# The Parish Councils of Assington, Bures St Mary, Leavenheath, Little Cornard, Polstead & Stoke by Nayland

## Interim combined response to Examining Authority's First Written Questions (ExQ1)

STOUR VALLEY EAST SEALING END COMPOUND:  
 PLAN VIEW  
 SCALE 1:200

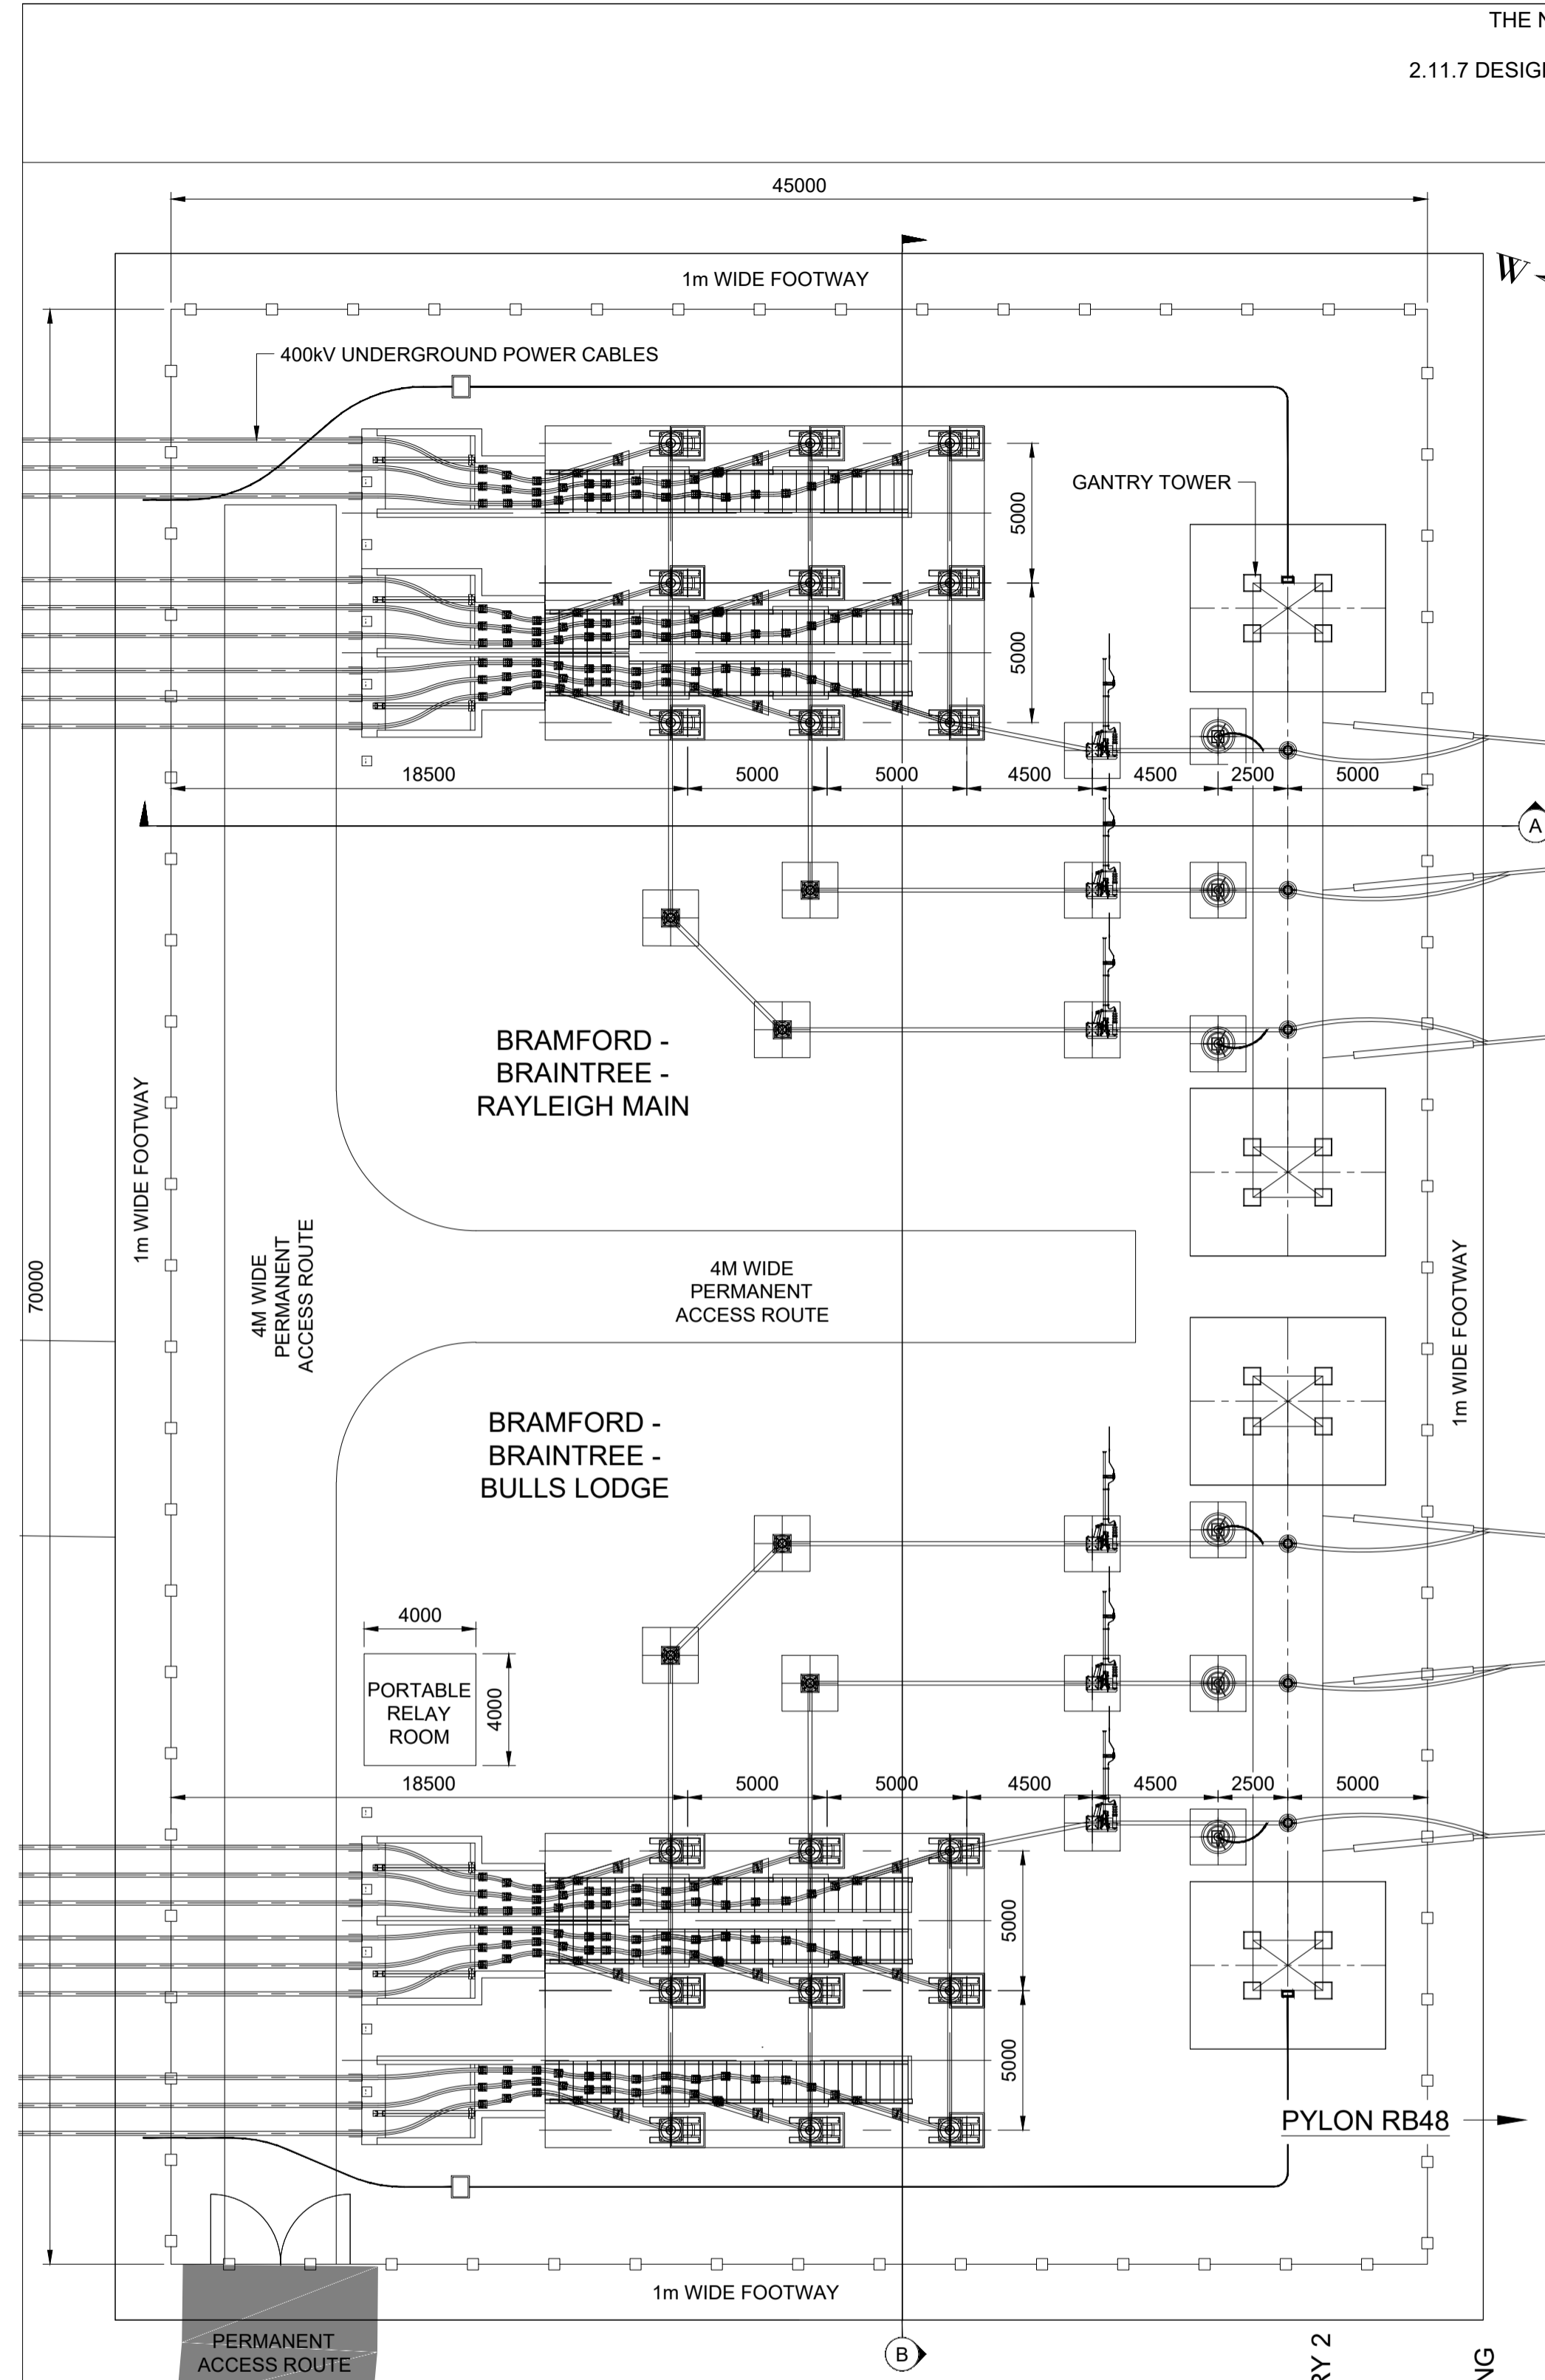
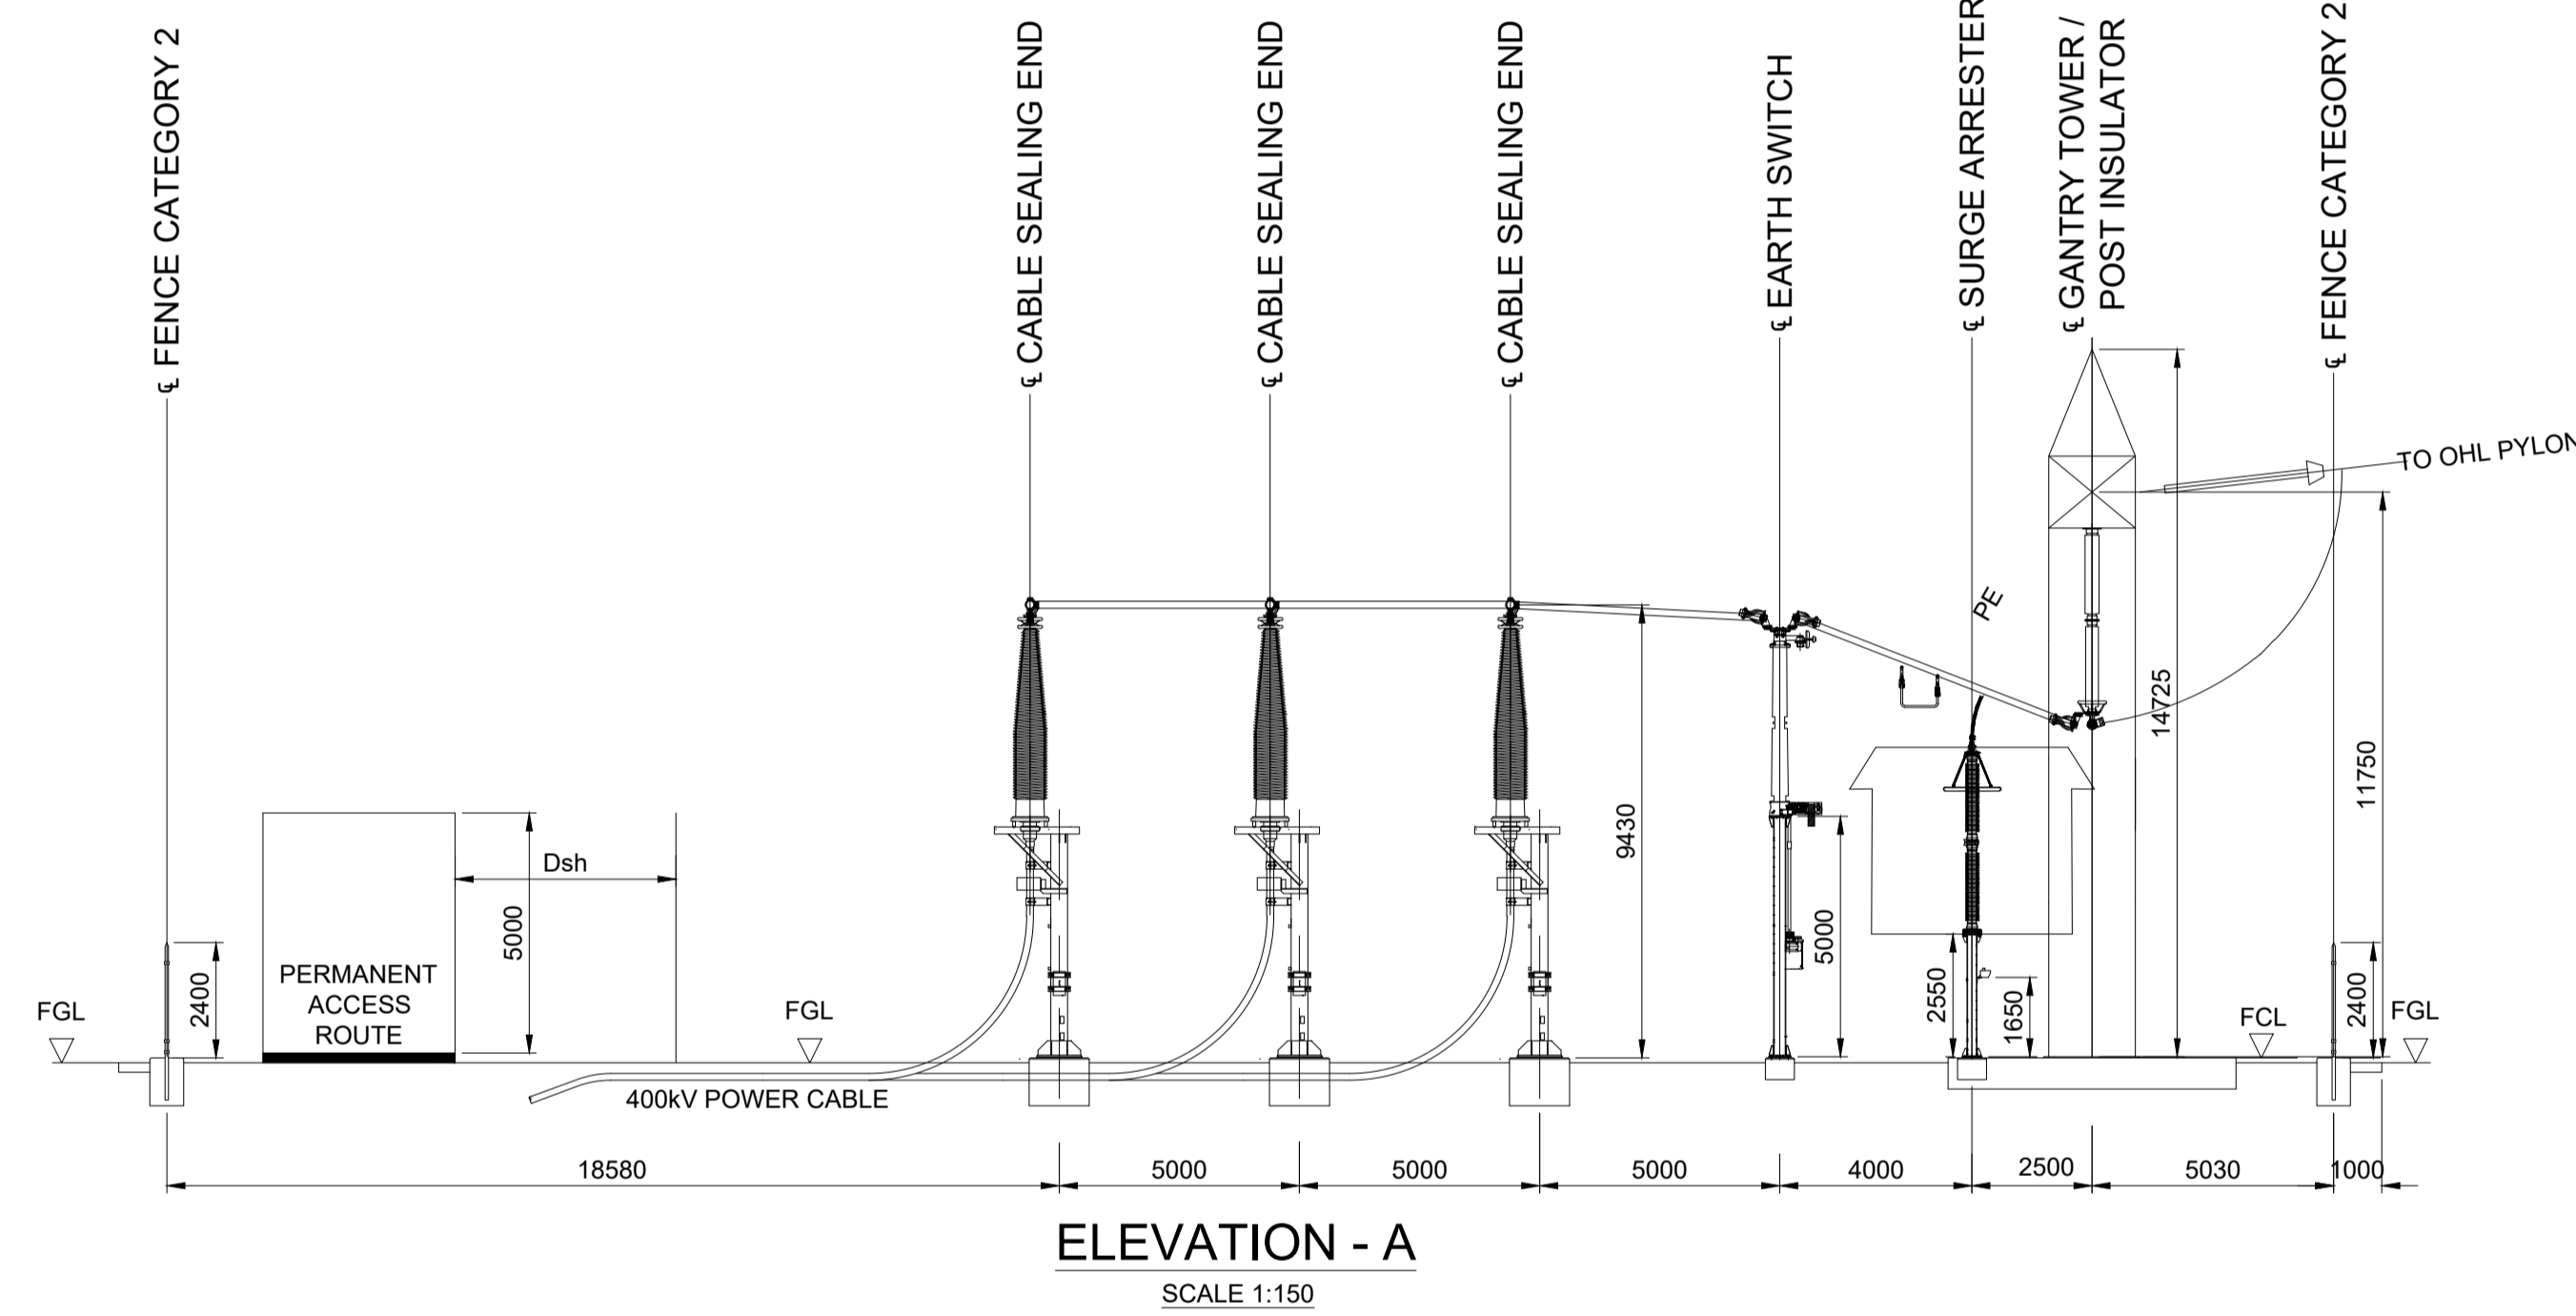
- 5.4 In addition, the Stour Valley East CSEC, while sited well to manage the impact of its visibility from the AONB, would have a permanent access road that would be highly visible from the SVPA, thus impacting its beauty and rural setting.
